Recommendation Report for Outline Consent

REF NO: FP/139/19/OUT

LOCATION: Land south of garage compound &
East of 12 Alfriston Close
Felpham
PO22 6QE

PROPOSAL: Outline application with all matters reserved for the erection of 1 No. dwelling.

Land East of 12, Alfriston Close, Felpham, West Sussex, PO22 6QB

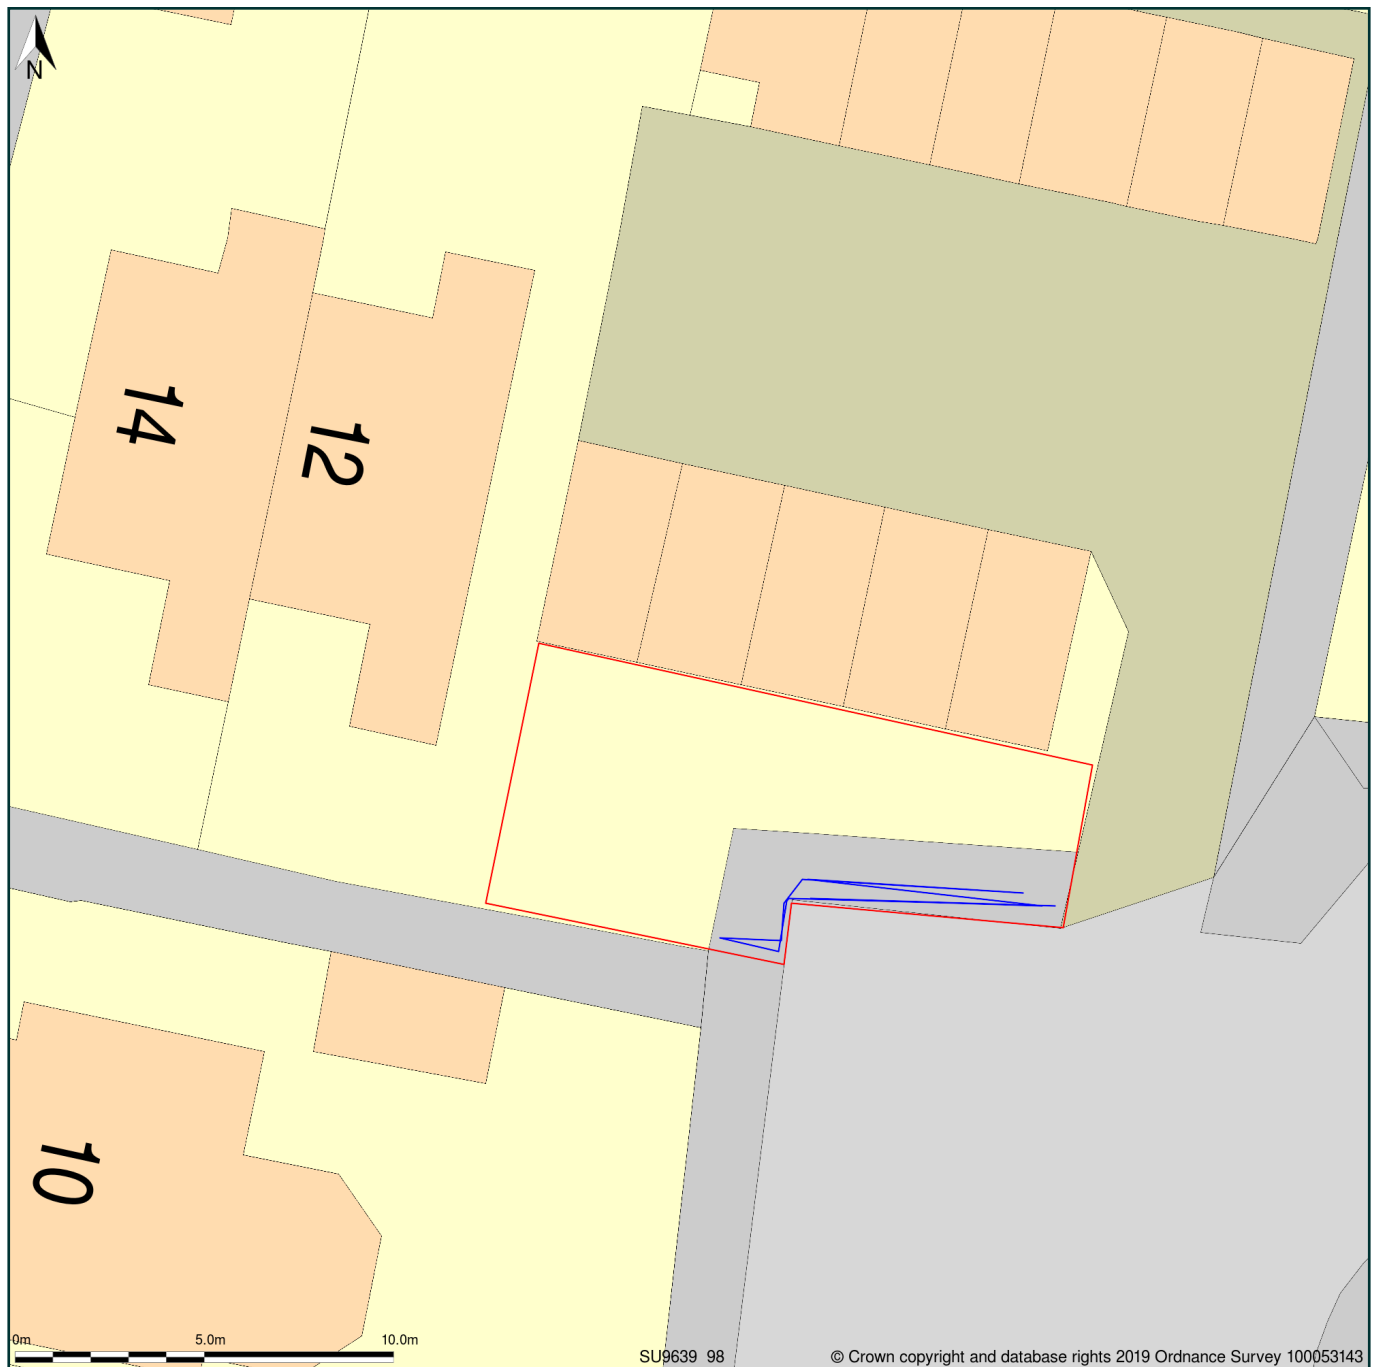
- It could not possibly hold a building measuring 7.5 x 7.5 metres because from the boundary of number 12 to the first tree is 4.2 metres not 7.5 metres.

FP/139/19/OUT, Land south of garage compound BLOCK PLAN 1:200 scale

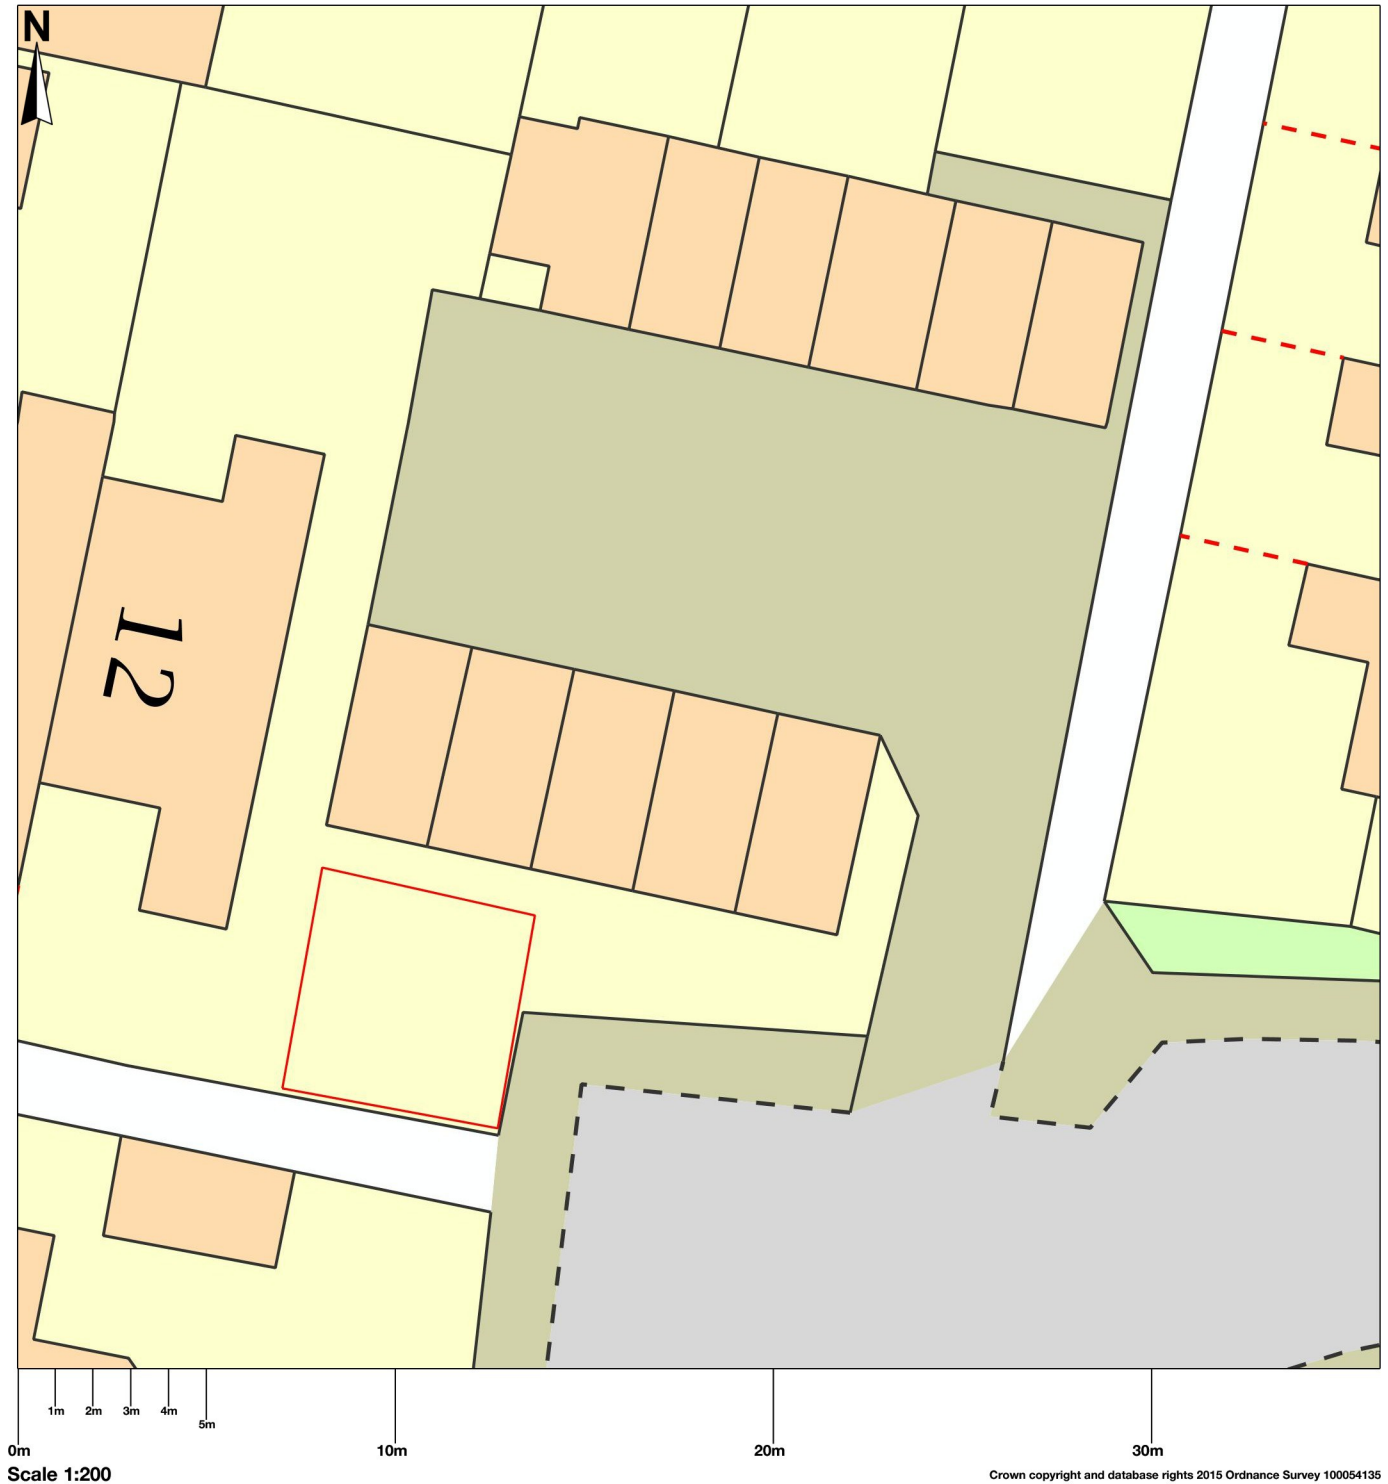
Notwithstanding the above, erection of dwelling house with footprint of 5.7m x 5.7m (as stated in submitted application form) within the site where the only footprint which would be possible to squeeze in is 5.6m x 5.6m (as shown on the submitted block plan) is not feasible. Therefore it is considered that the proposed development would be inappropriate due to the position and the size of plot.

It is not possible to properly assess the residential amenity implications of the proposed layout due to the lack of elevation or floor plan drawings. However, it would appear that the dwelling on the illustrative layout would be approximately 2m from the existing dwelling No12 and within 1m separation distance from the rear of existing garages to the north, sitting literally on the edge of the existing pavement would result in an overbearing structure regardless of its size with rather restricted living conditions for the prospective occupiers.

In respect of external standards, given that this layout plan is illustrative only, the layout has not been checked in detail. However, the plot is not big enough to build the dwelling, therefore it is considered unlikely that the scheme as supplied will comply with these standards.
